Planning Application Ref: LU/338/20/T

Location: 3 Butts Mead, Wick, Littlehampton, BN17 6GP

Description of works: Reduction of 1no. beech (T1) to 10m high and radial spread on southern canopy to 3m reduction of 1no. beech (T2) to 10m high and radial spread on southern canopy to 3m

Plan 1.0

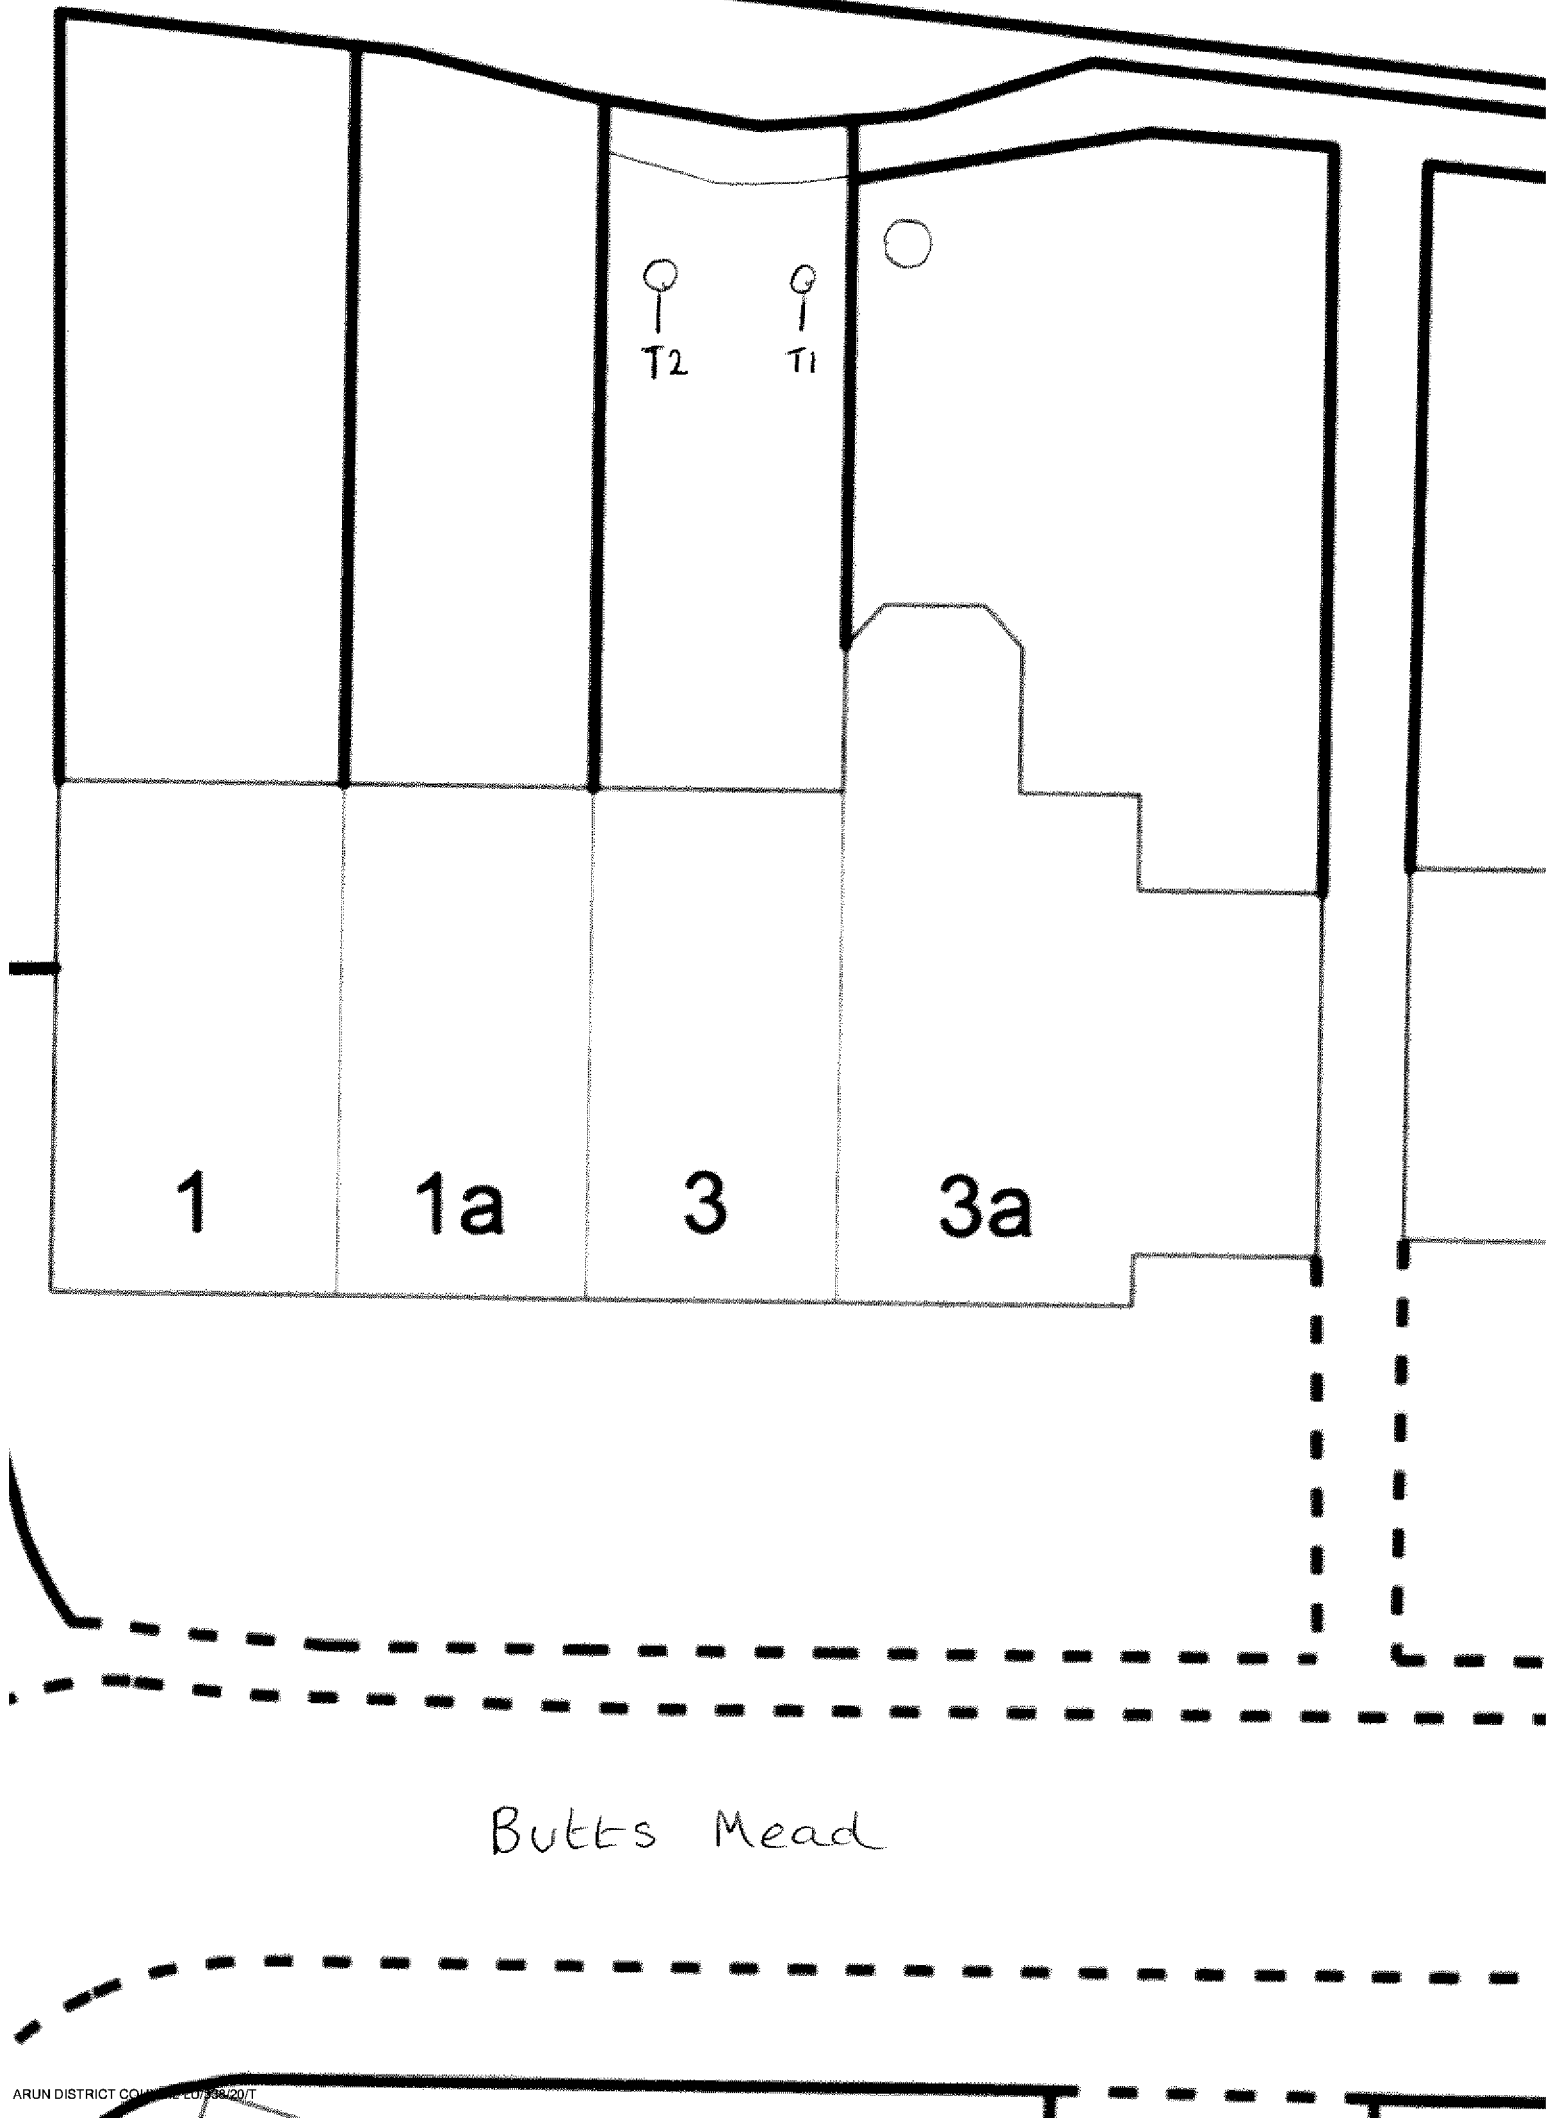
- Outwardly and from distance these trees appear to be in a fine physiological state and assumed to be so in the absence of any information/evidence provided to the contrary. T2 is of similar dimensions and stature to that which grows in the neighbouring rear garden (3a); T1 has more slender, drawn-up form. Together they provide mutual support and are a cohesive group.
- Although visible in part from surrounding properties and public highway (footway and carriageway) they have come to dominate the applicant's rear garden and retain high growth potential. As such, it is entirely reasonable that some containment pruning be applied to limit their influence.

- The work proposed is justified on arboricultural grounds. These are established trees providing some visual amenity and should be carefully pruned to maintain reasonable enjoyment of residential property and with respect for natural tree form.
- Beech trees have a poor tolerance to hard pruning. If the work is undertaken to a high standard and at the right time, then there should be no significant harm to their ongoing health and vitality and thereby remain a visually interesting feature in the local landscape.

- Part a) Where whole branches are to be removed and final cuts made close to the trunk or branch union they are to be made as shown in Figure 2 of BS3998:2010
- Part b) Where branches are to be shortened back the final cuts are to be made at the correct angle shown in BS3998:2010 and adjacent to a live bud or lateral.
- Part c) Where branch reduction pruning has occurred previously, then the removal of crown material which has developed since the last operation must be done sympathetically and with respect to established 'knuckles' so as not to extend beyond the point of origin.
